**KIRKLEES METROPOLITAN COUNCIL
INVESTMENT & REGENERATION SERVICE**

DELEGATED DECISION TO DETERMINE APPLICATIONS FOR LISTED BUILDING CONSENT

Reference No:	2024/65/91037/W
Site Address:	Edgerton Cottage, 15, Edgerton Road, Edgerton, Huddersfield, HD3 3AA
Description:	Listed Building Consent for replacement windows and doors (within a Conservation Area)
Recommending Officer:	Sebastian Pickles

DECISION – GRANT LISTED BUILDING CONSENT

Drawing Number 2466 - D - 20 - 003 Revision A

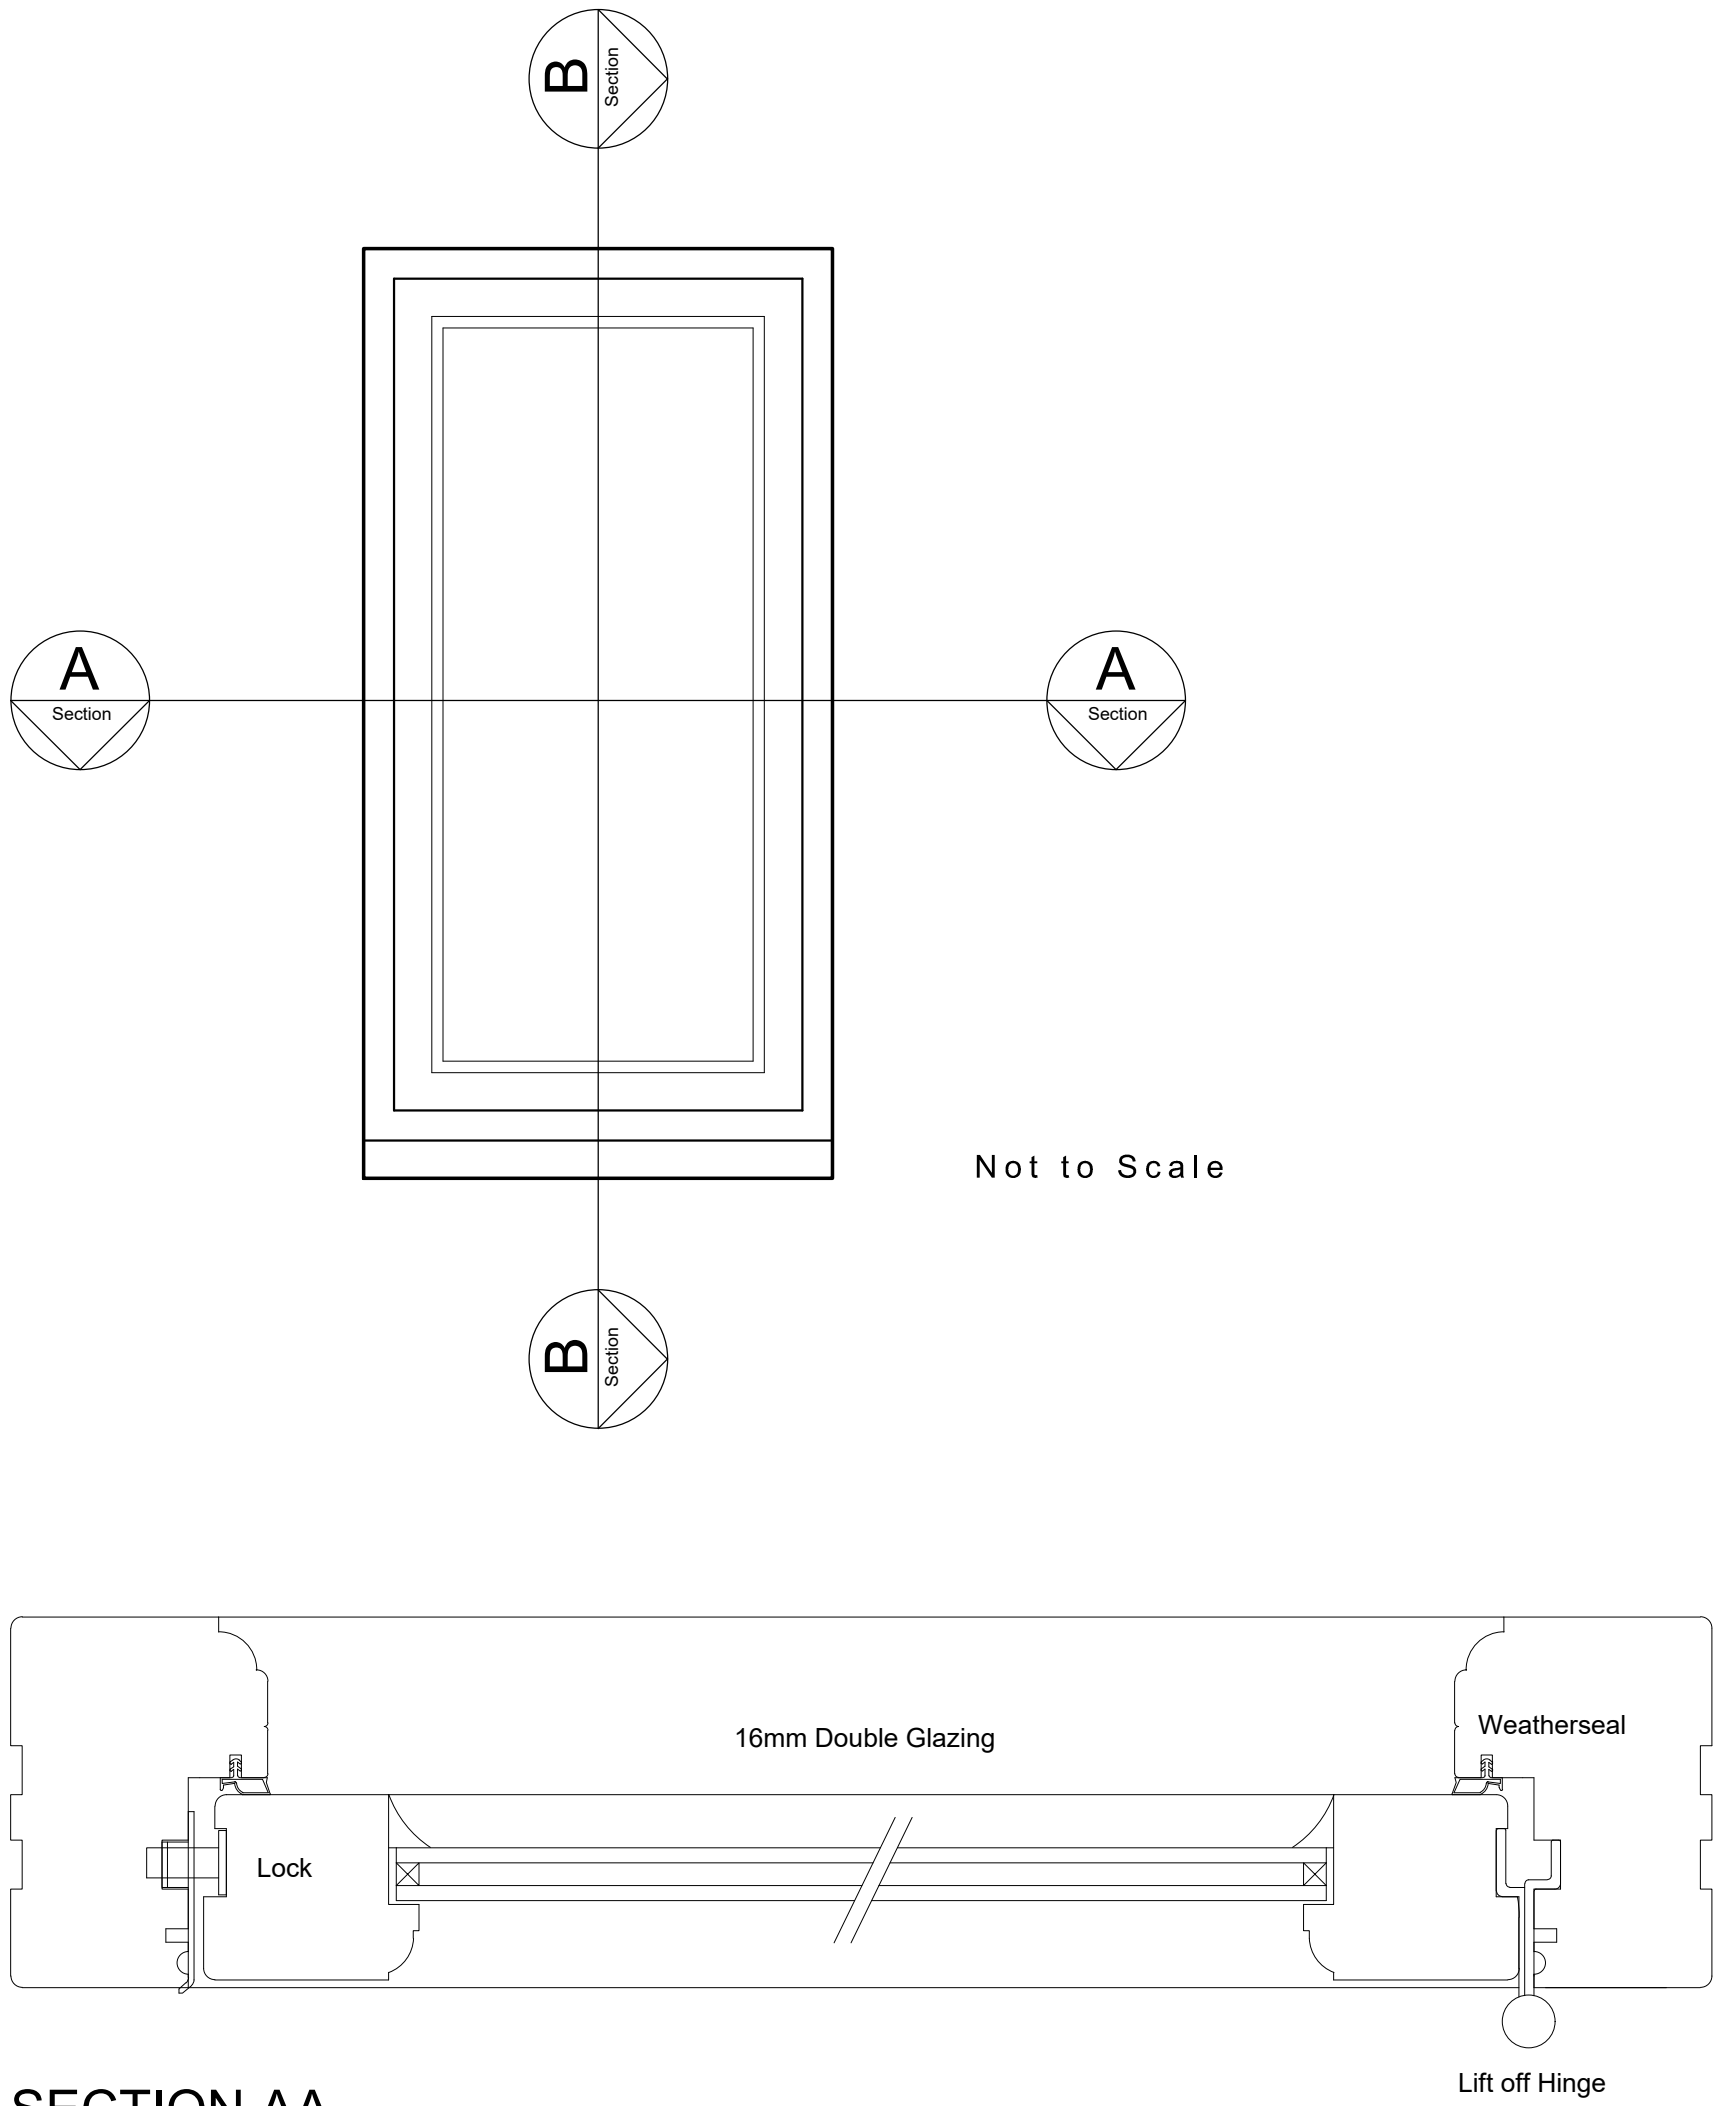
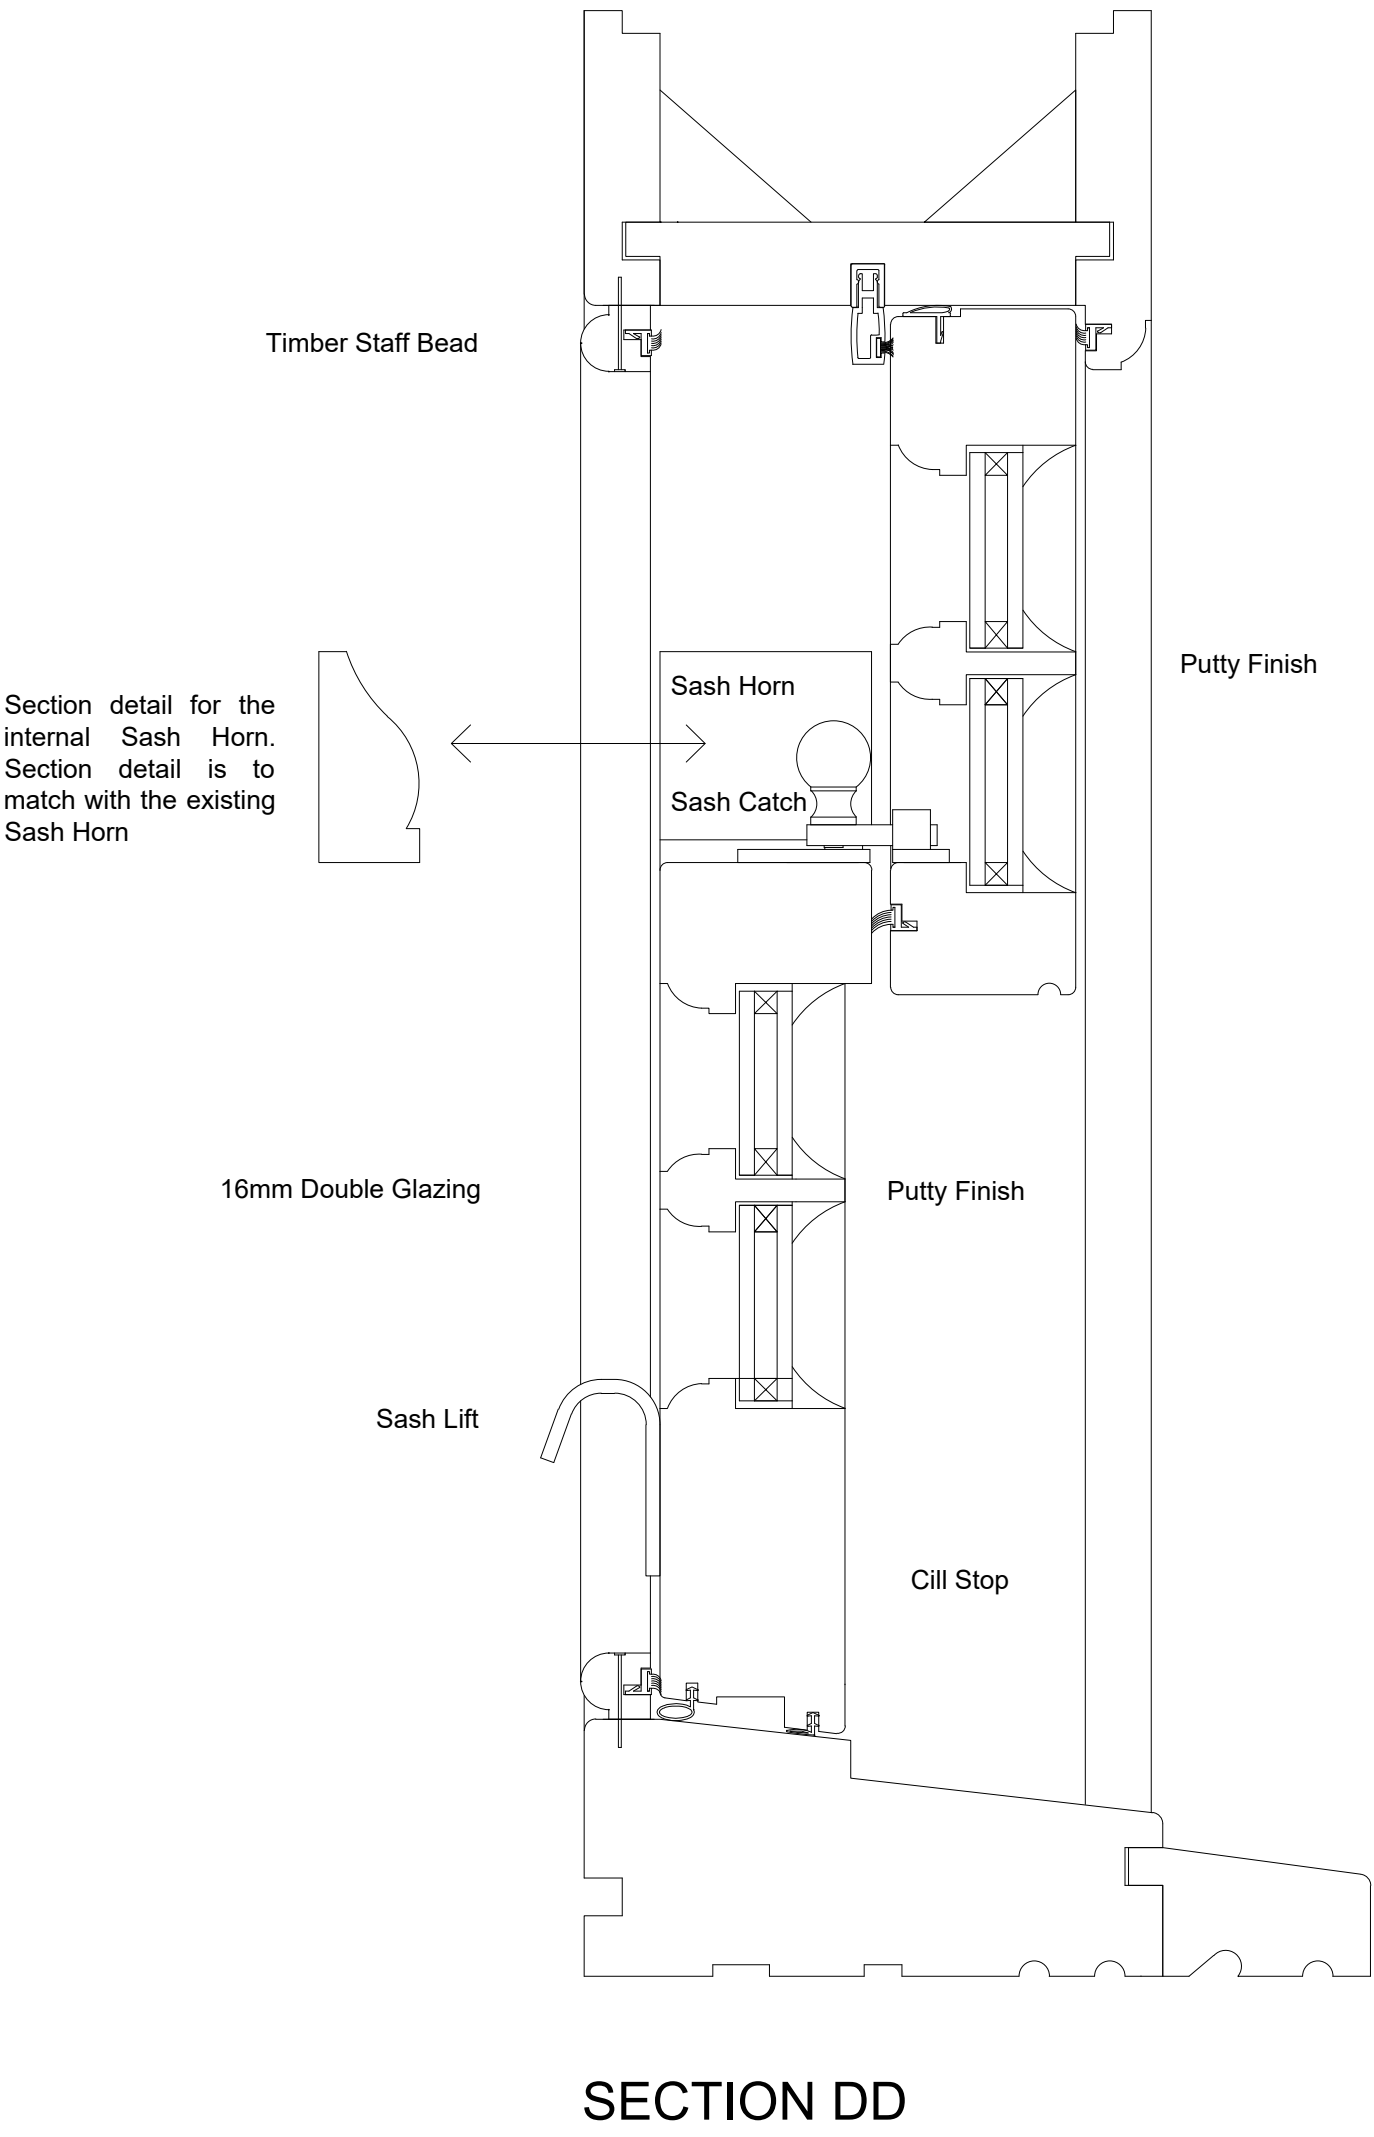
As stated, the proposals are for the replacement of the existing windows and doors to the building. While this will see the loss of the existing frames, it is considered that this will not have a detrimental impact on the character and significance of the building. The replacement frames will be of a match to the existing ones in every respect, saved that the new frames will have slim line double-glazed units. The replacement frames are to be putty finished which again will ensure there is a matching appearance to the existing.

3. Notwithstanding the submitted plans, joinery details of window 15 as shown on plan 2466-D-20-002 – A shall be submitted to the Local Authority for approval in writing. The joinery drawing shall be submitted at a scale of 1:20 and shall include both section and profile details of the proposed window. The works shall be completed in accordance with the details.
